DECISION DELEGATED TO HEAD OF PLANNING

Application No: H16-1016-24 **Applicant:** K Szuskiewicz
Proposal: Erection of Rear Extension - Retrospective
Location: 111 Bourne Road Spalding Lincolnshire
Terminal Date: 13th March 2025

Dwg No. **A** **PROPOSED**
Scale: 1:100 **ELEVATIONS**

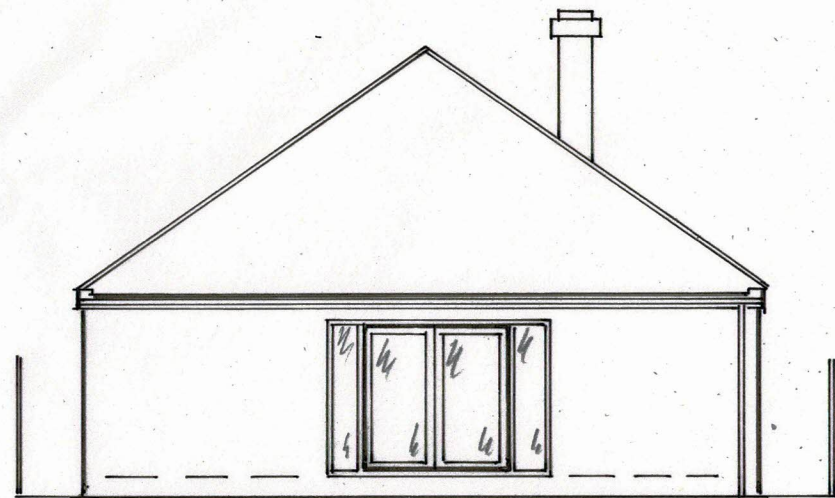
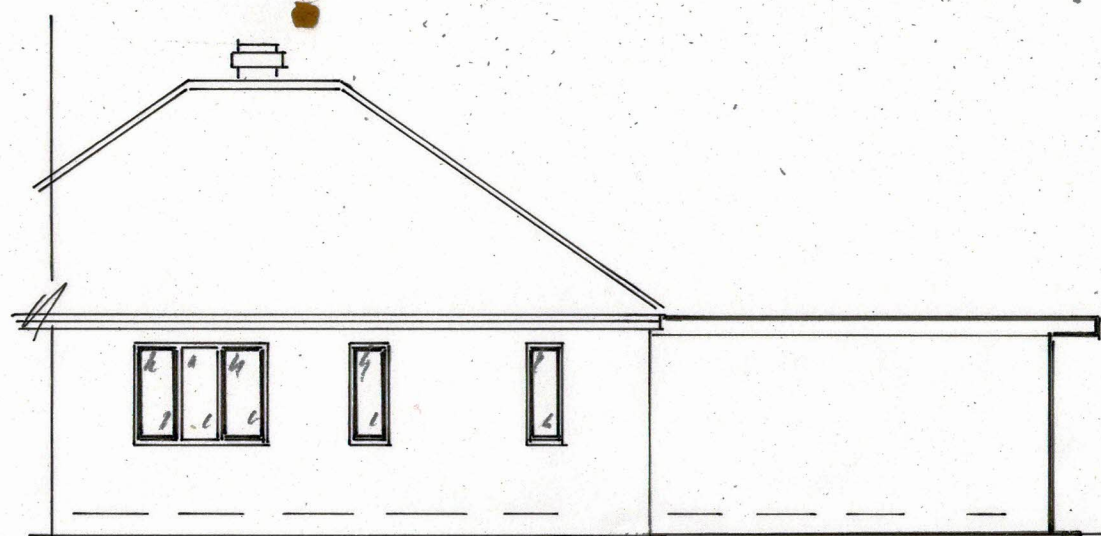
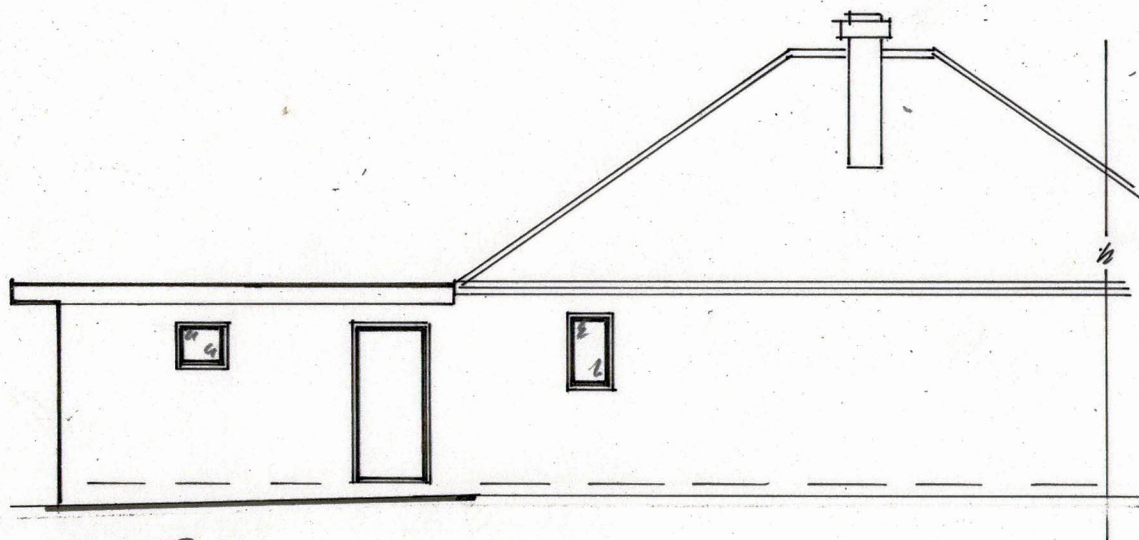
This is a retrospective, householder application for the erection of a flat roof, rear extension. The extension would replace an existing rear component which measured 4100mm (width) by 5350mm (depth). The proposed extension has a width of 8925mm (running the length of the house), with a depth of 5350mm. The height of the proposal is 2900mm. The extension is rendered white.

The development is relatively bulky in appearance and is of little architectural merit. That being said, as a rear extension, with allotments to the south, the actual tangible impacts upon the character and appearance of the area are limited. As such, it cannot be said to have a significant detrimental

While render is present on the site currently, this is not the lawful material for the building, as no permission was sought for the change from the previous red brick. That being said, it is not uncommon in the wider area and as such would have limited visual impact upon the character of the wider area. The previous red brick is not integral to the character of the building or the wider sense of place. As such, the proposed materials are considered acceptable.

The windows in the extension are sufficiently low lying as to prevent overlooking.

The proposal would create some overshadowing in both neighbouring gardens; however, it is not considered that this would significantly detrimentally impact upon the amenity of these neighbours. Any shadow cast would be within small portions of residential gardens, for a limited period of time.
